Project No. 21101

**Re: PA22-024- Marysville 44th PRD – Technical Review 3  
7315 / 7417 44th St NE – APN(s) 30053500303700 / 30053500303600**

This letter is provided as response to comments dated May 16, 2023. Each item has been carefully reviewed and considered and the following is a summary of how each item was addressed.

DRAWING: **C3**
 SHEET: **3** OF **9**

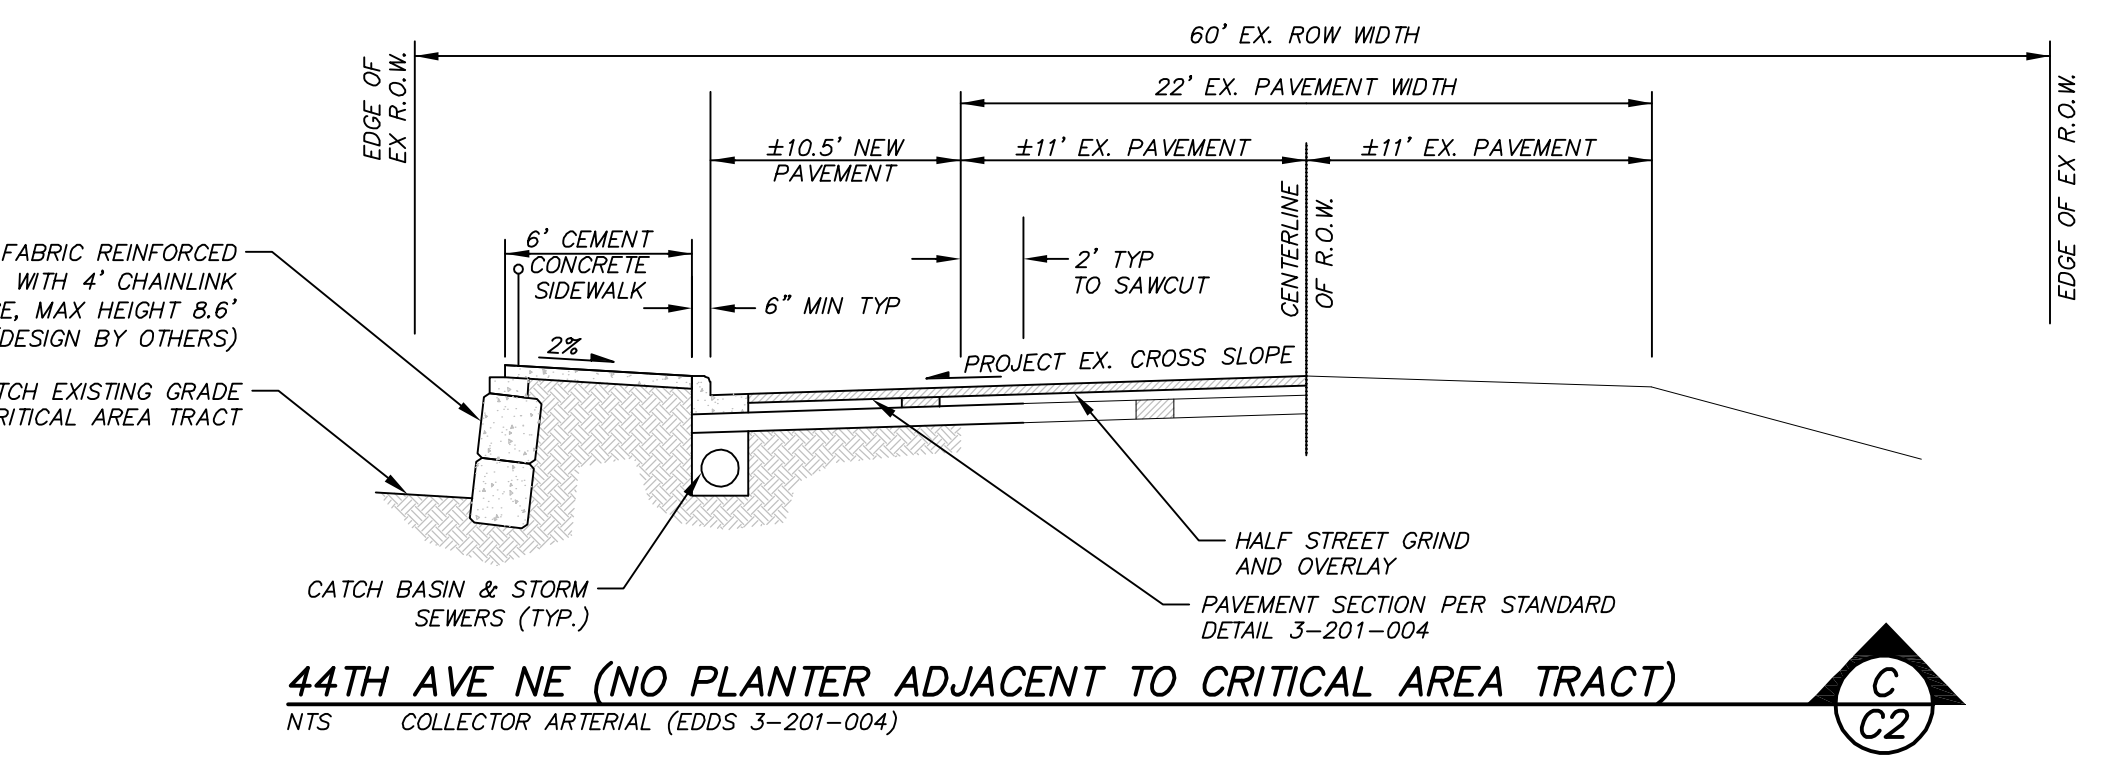
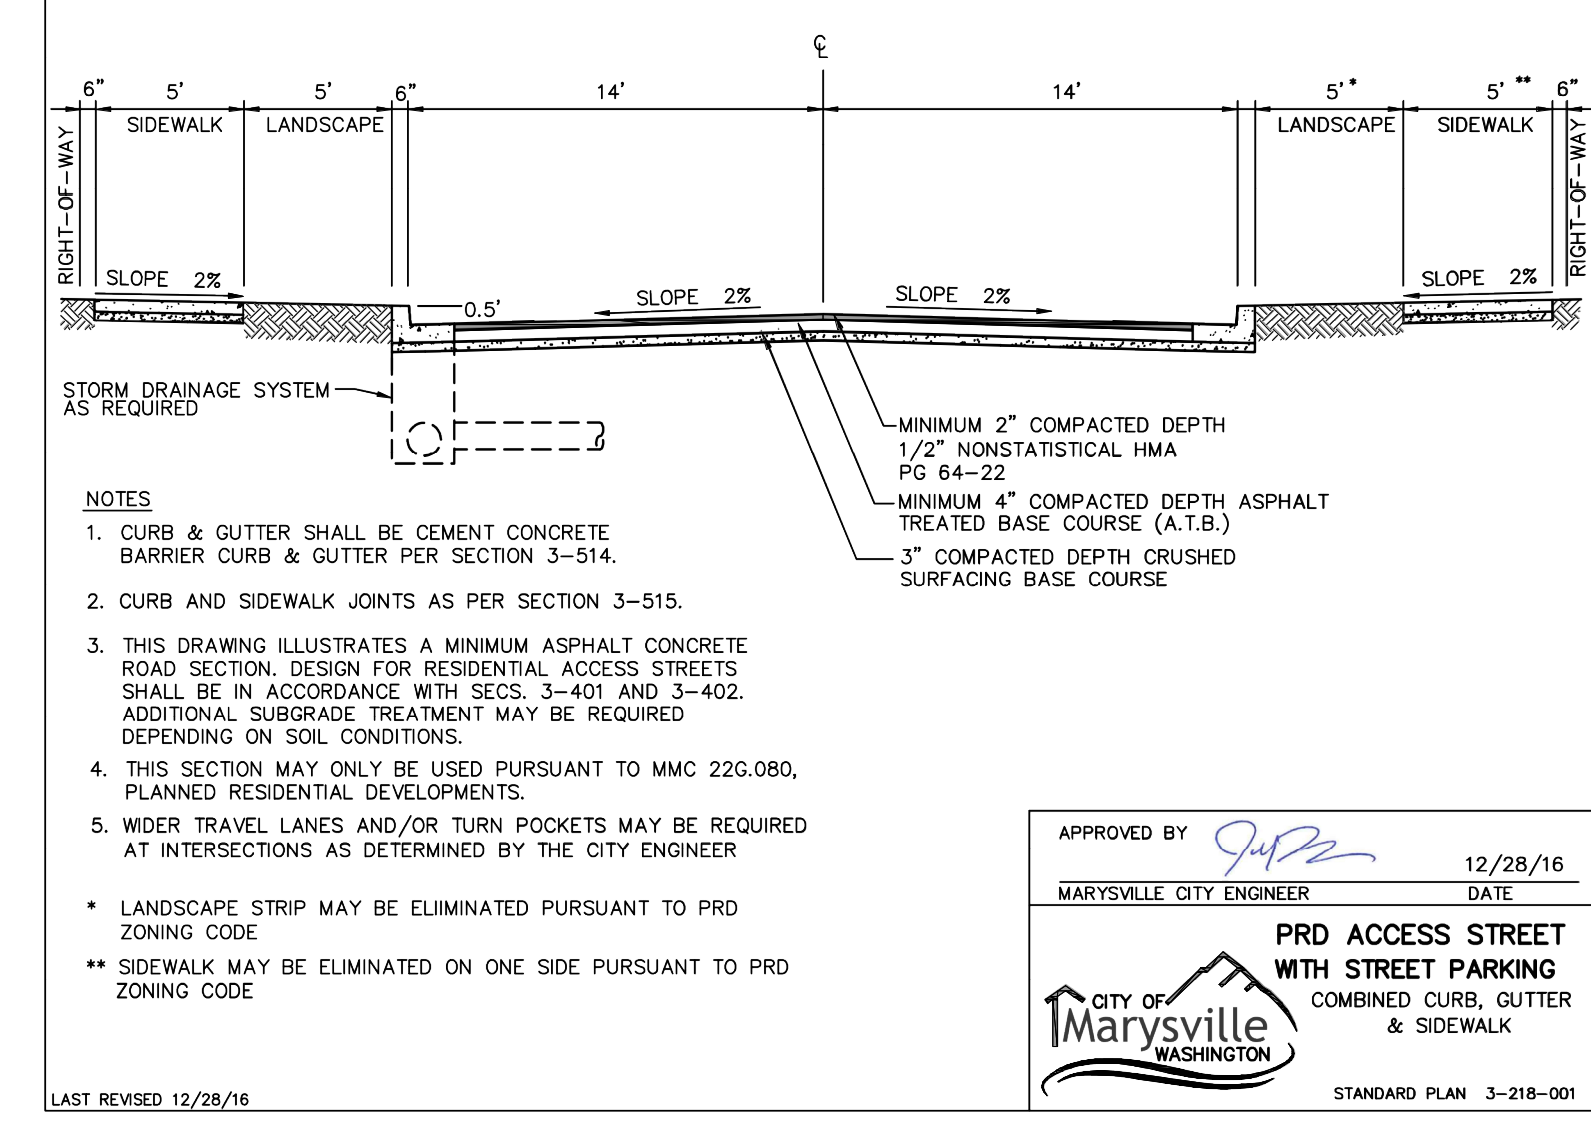
1. The auto court portion is 26 foot wide, but the sidewalk will be constructed level with pavement to allow for a wider section in case of obstruction by illegally parked cars.

***The auto court design and typical section has been revised to construct the sidewalk level with the pavement to provide a 26' wide driving surface.***

DRAWING: C7
 SHEET: 7 OF 9

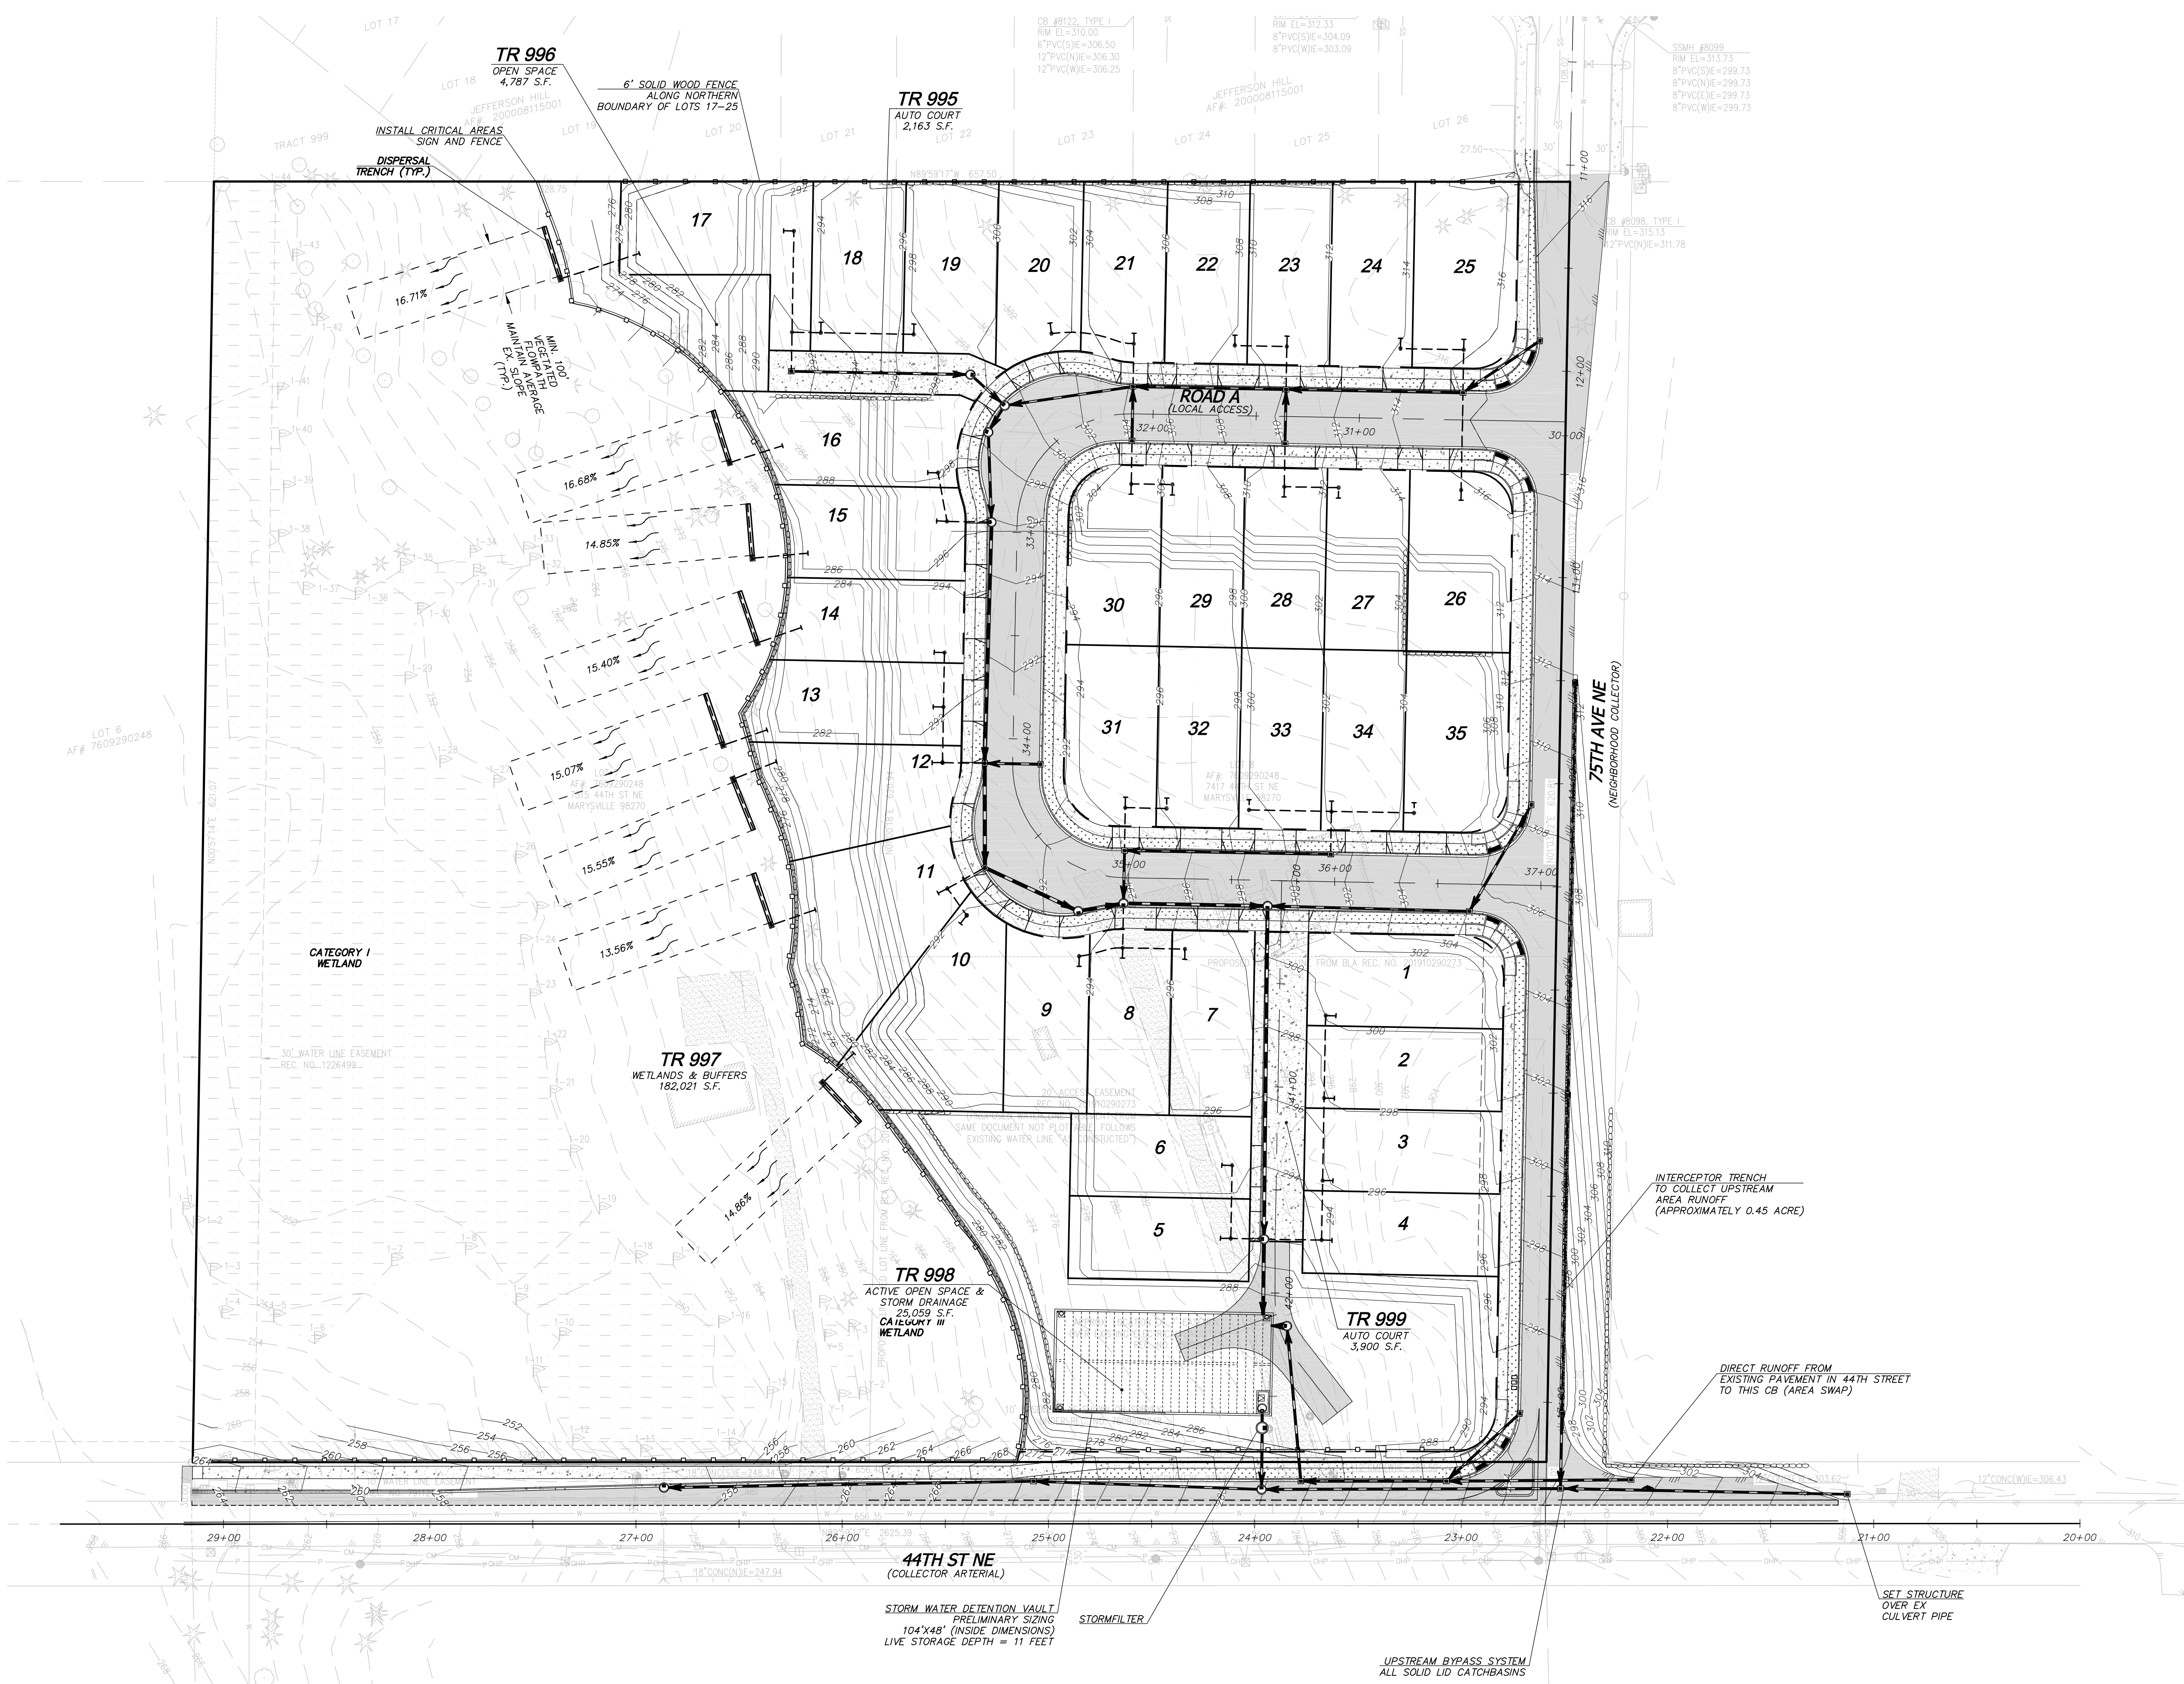
1. No water details shown, including size of water main;

2. Looking at road profiles air vacs will be necessary. Install in accordance with Design and Construction standards 2-070 part G;

3. Live tap on 44<sup>th</sup> Ave.

***Callouts of typical water main sizing has been added. Full detail design drawings will be provided during the final engineering design of the plat.***

***A callout for the air vac symbol located near the northern intersection of Road A and 75th Ave NE has been added. This is the only high point in the system that will require an air vac.***

***Connection revised to show a hot tap into the existing main.***
